**New Request for Advice - Blue Gum Community School (SSD-10444) (Hornsby Shire)**

Thank you for your correspondence via Major Projects Planning Portal (ref: PAE-3566) dated 5 June 2020 requesting Transport for NSW to provide advice regarding the above.

## TAB A – TfNSW Comments – SSD 10444 EIS Blue Gum Community School

SITE PLAN

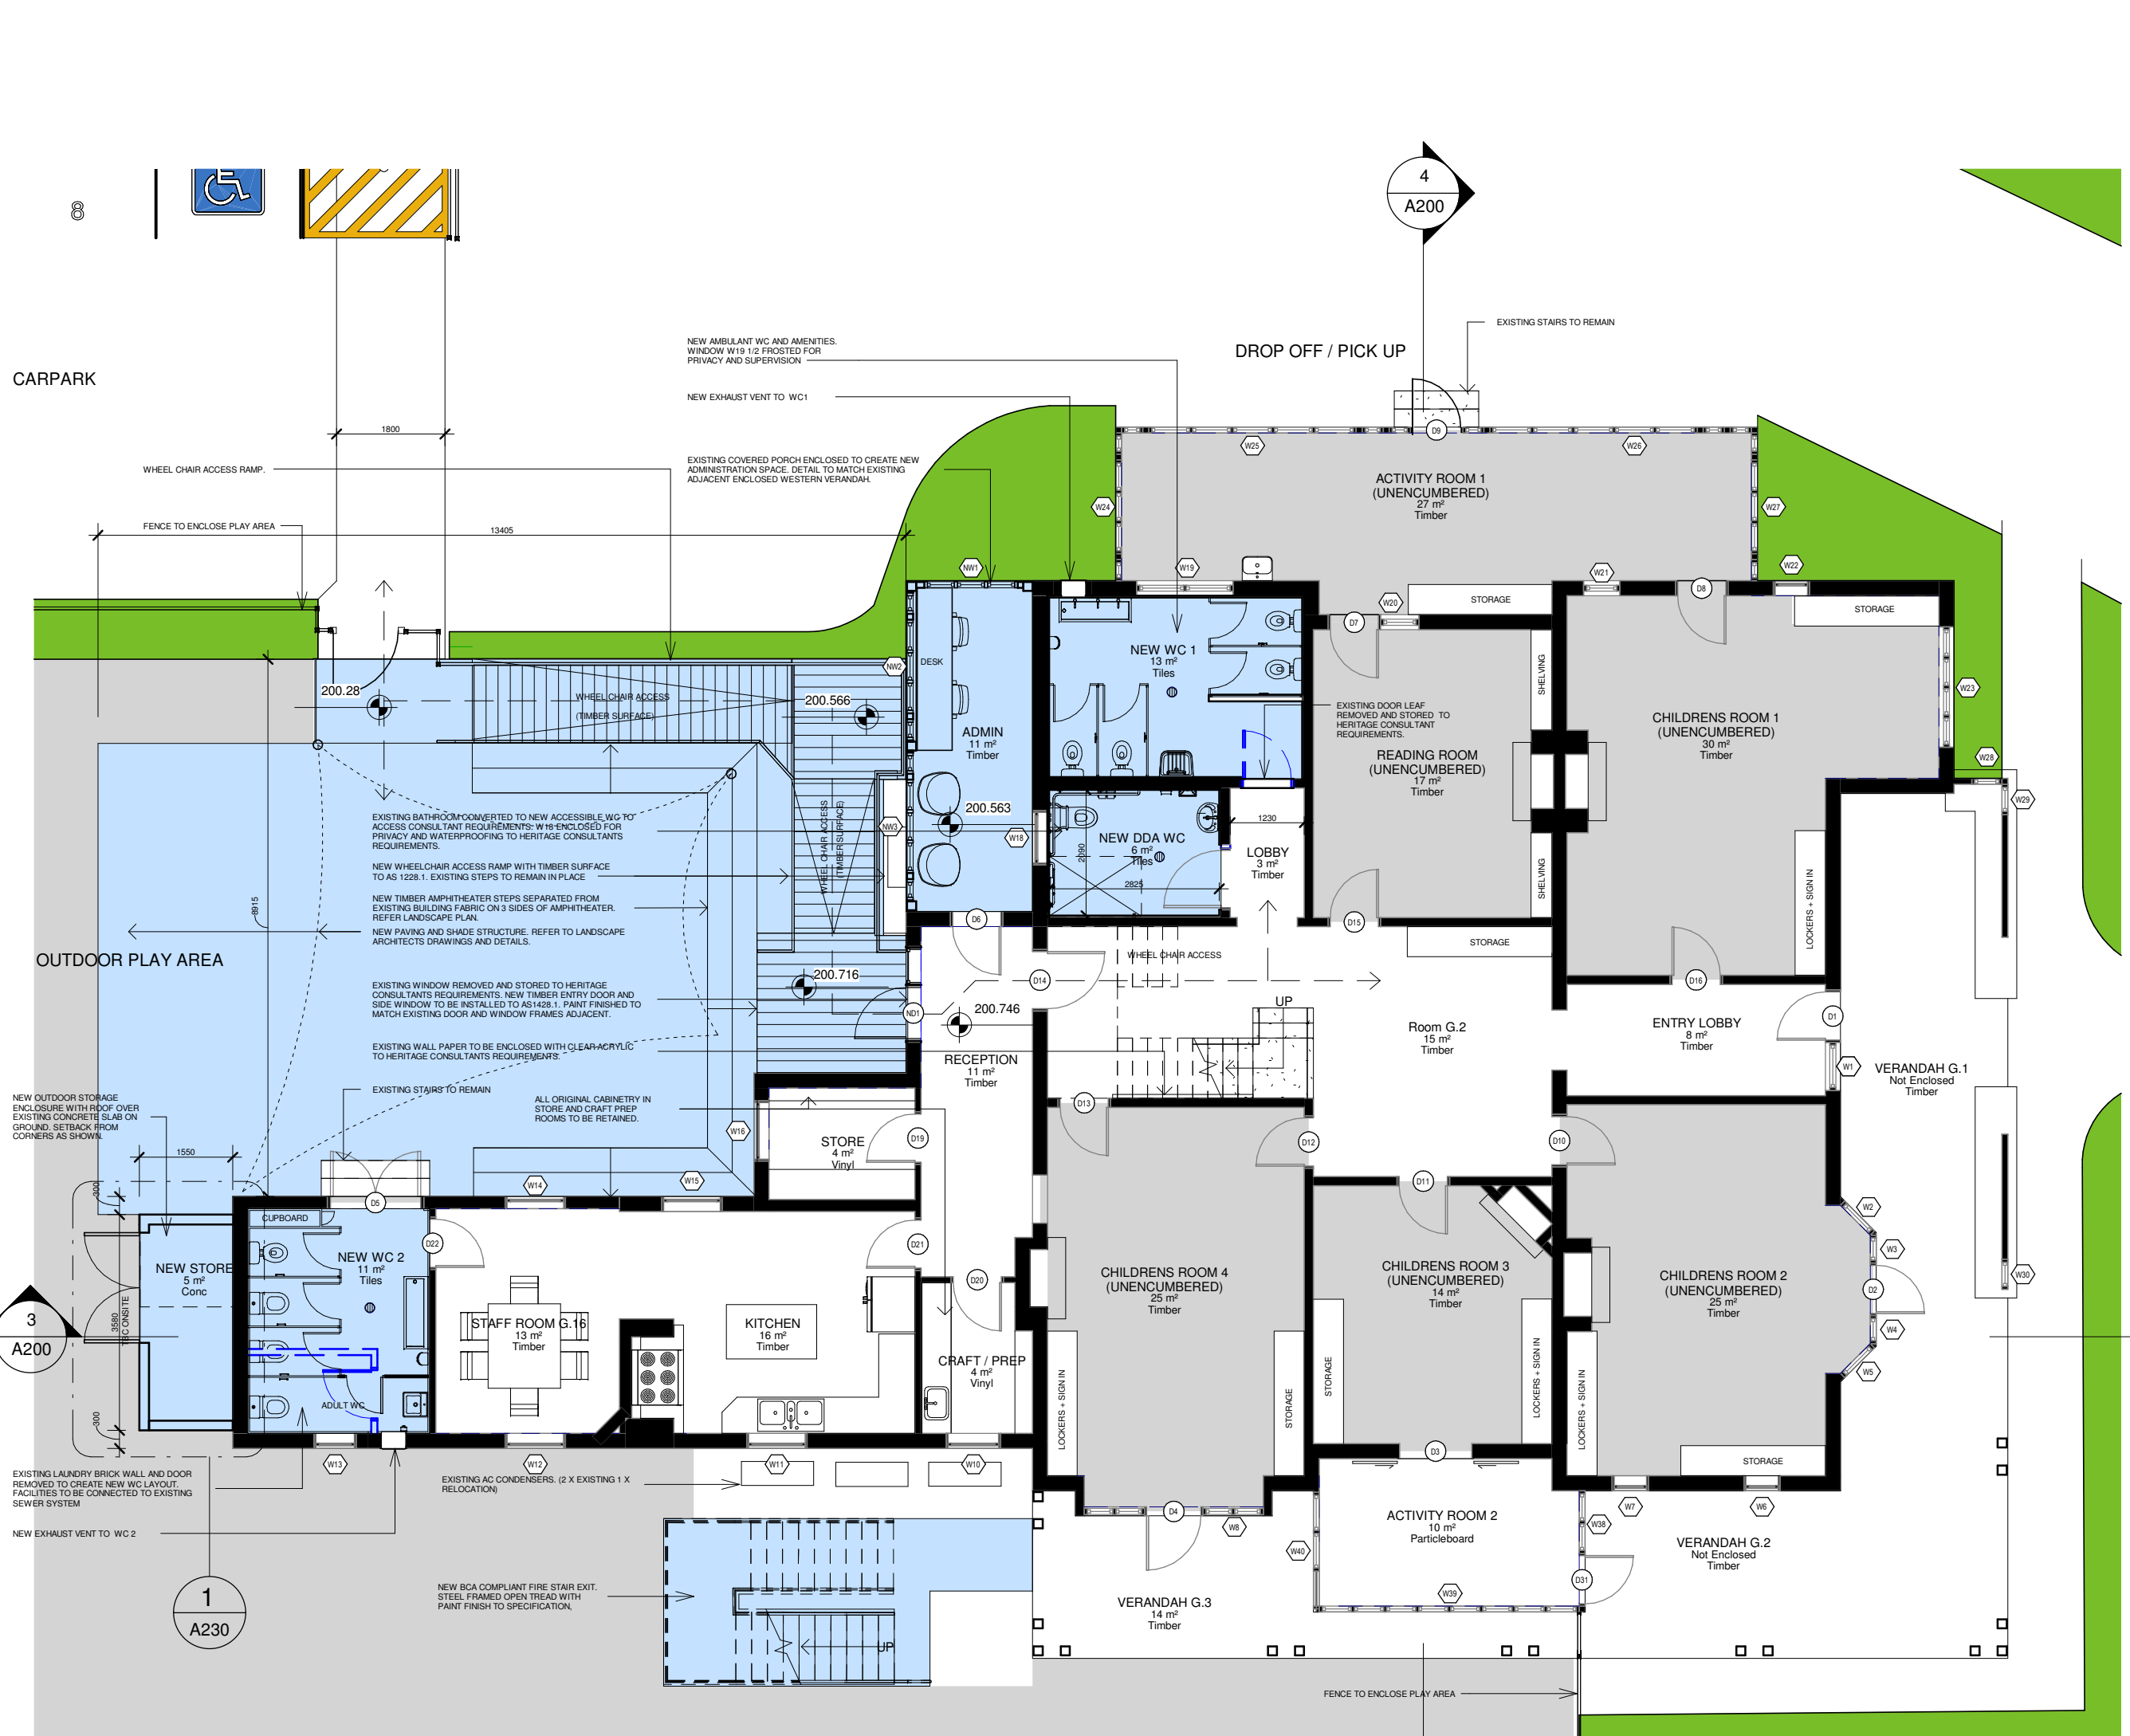
It is also unclear how the pick/drop off area will work as the access from Rosemead Road appears narrow and may be difficult for vehicles to maneuver within the site.

Prior to the issue of a construction certificate, a plan shall be submitted to the certifying authority which demonstrates the layout of the proposed car parking areas associated with the subject development (including, driveways, grades, turn paths, sight distance requirements in relation to landscaping and/or fencing, aisle widths, aisle lengths, and parking bay dimensions) are be in accordance with AS 2890.1- 2004, AS2890.6-2009 and AS 2890.2 – 2002 for heavy vehicle usage and that the swept path of the longest vehicle (including garbage trucks, building maintenance vehicles and removalists) entering and exiting the subject site, as well as manoeuvrability through the site, is be in accordance with AUSTROADS.
